PLANNING AMENDMENT

OFF CHURCHGATE, WIMBORNE (PLOT 6)

3 BEDROOM BUNGALOW + GARAGE
(PLOT 6)

Application no: H23/0727/97

DRAWING NO.:
AH-BP (1/1)

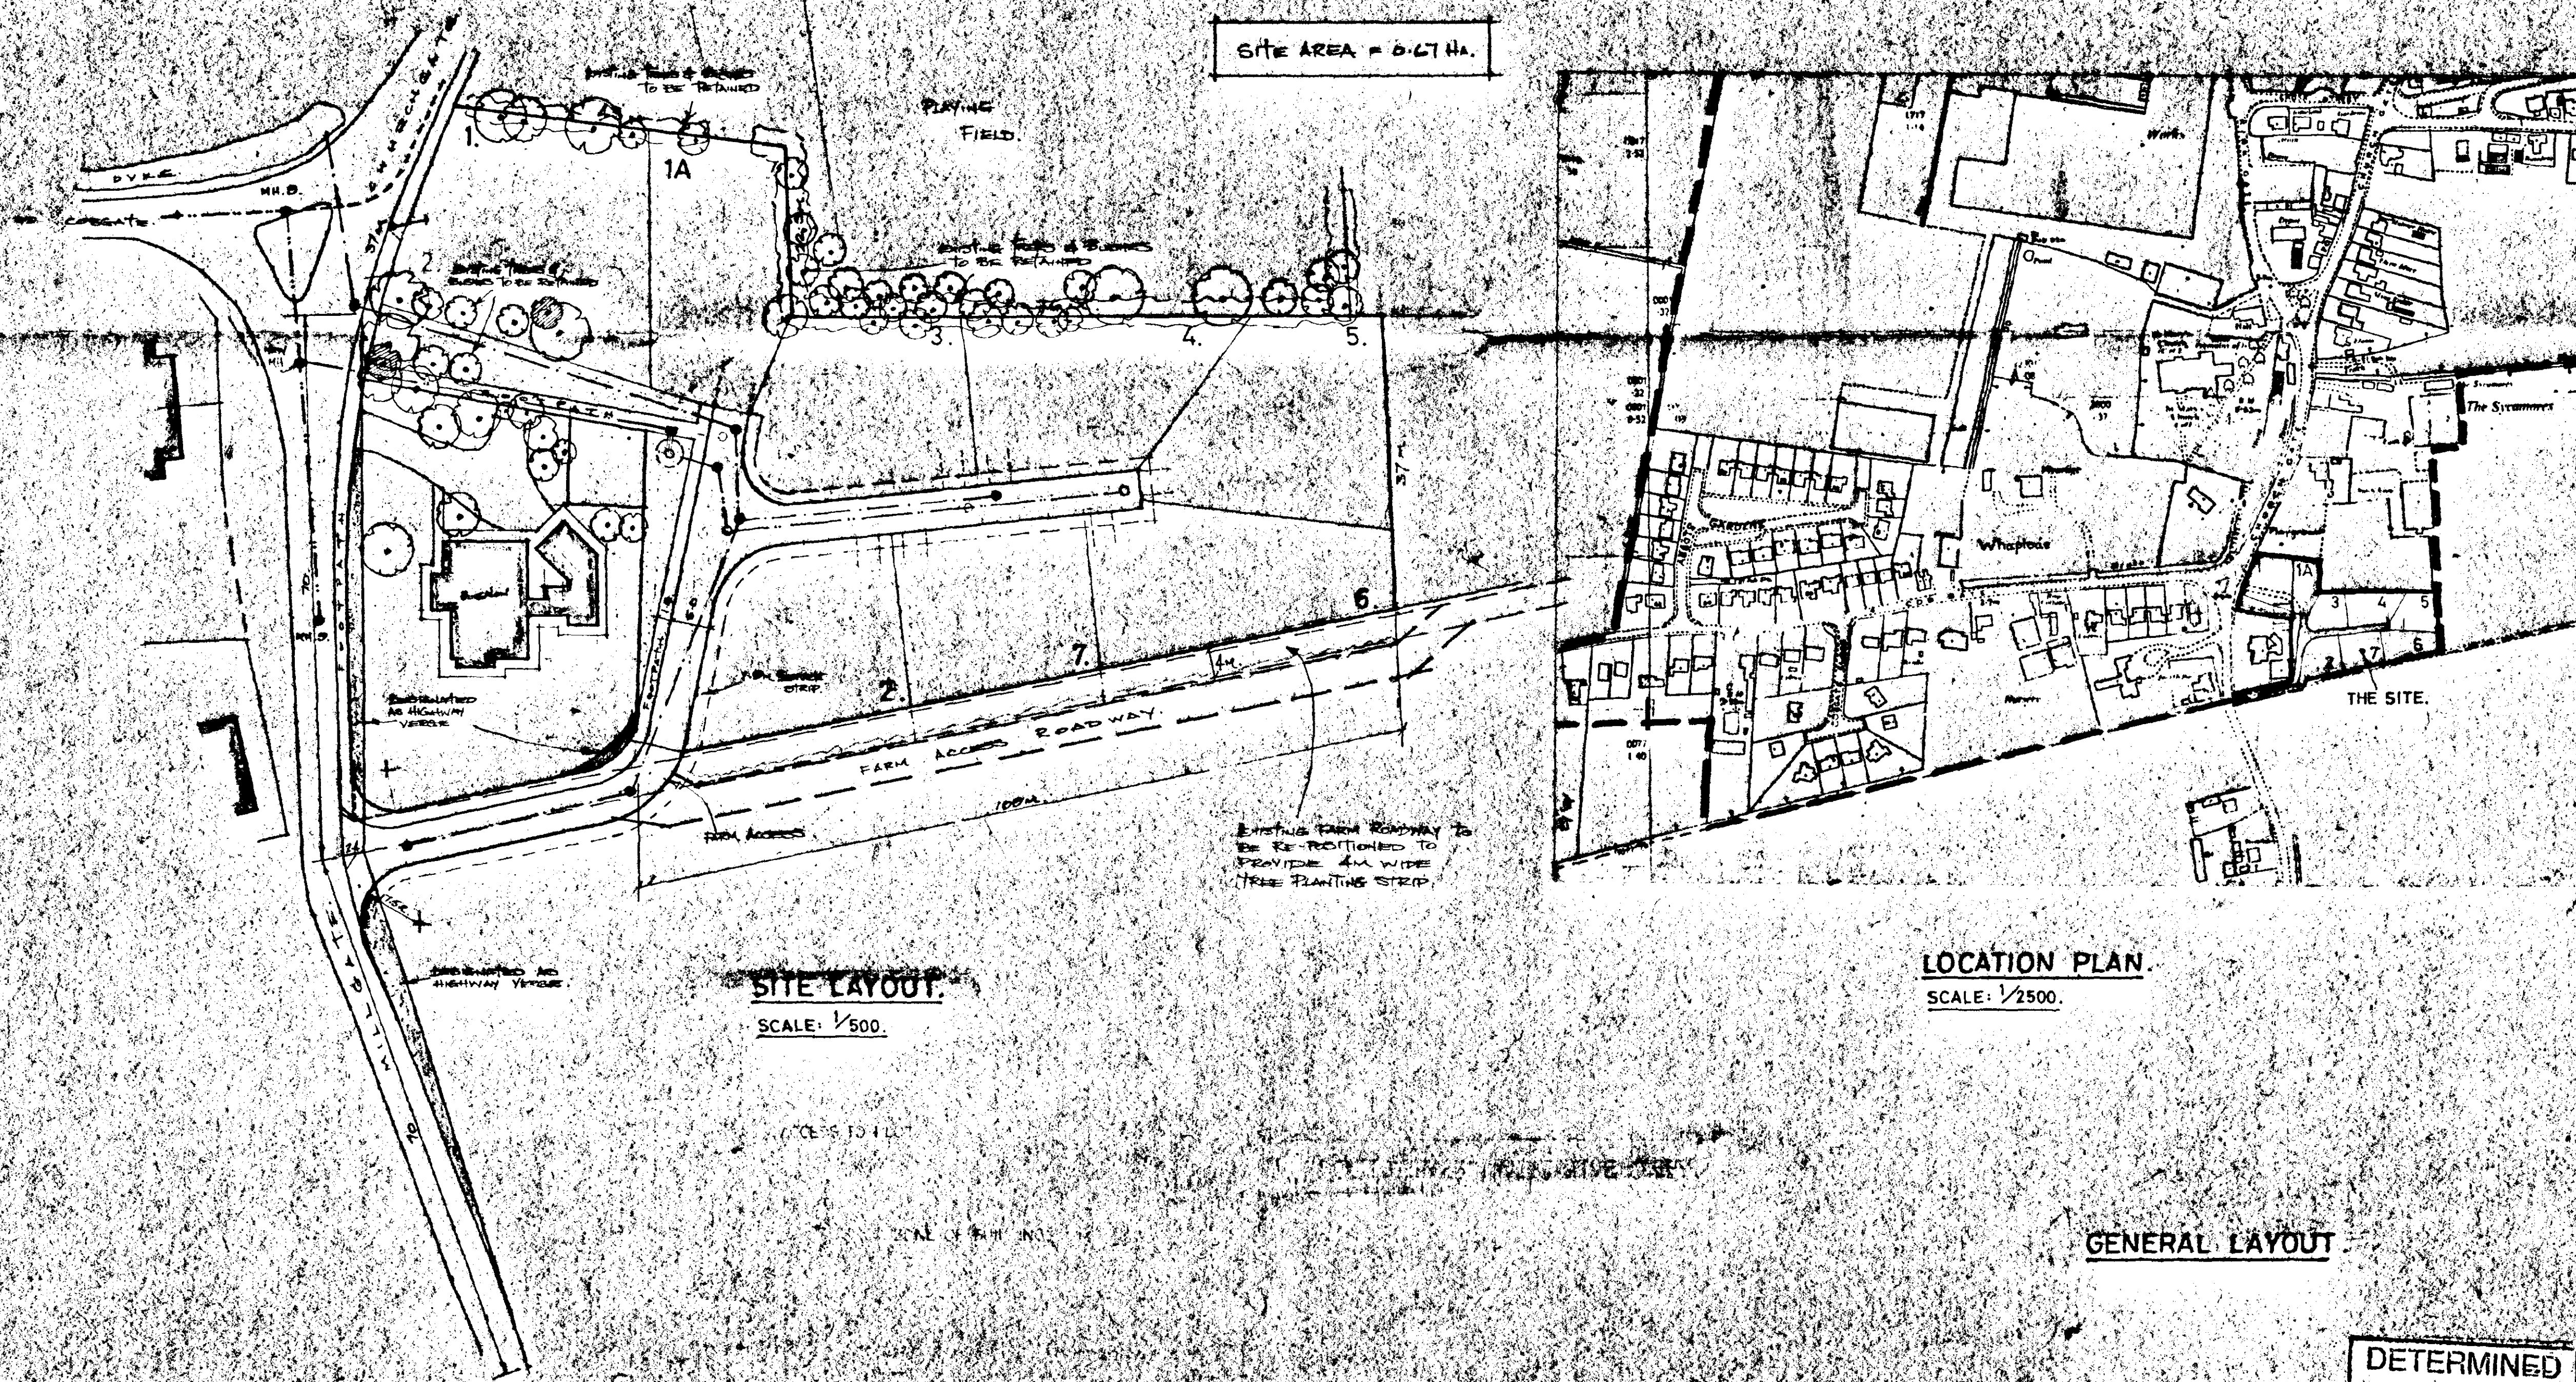
AMEND FOOTPRINT

Amendment: Amend footprint (Drawing No. AH-BP.1B)
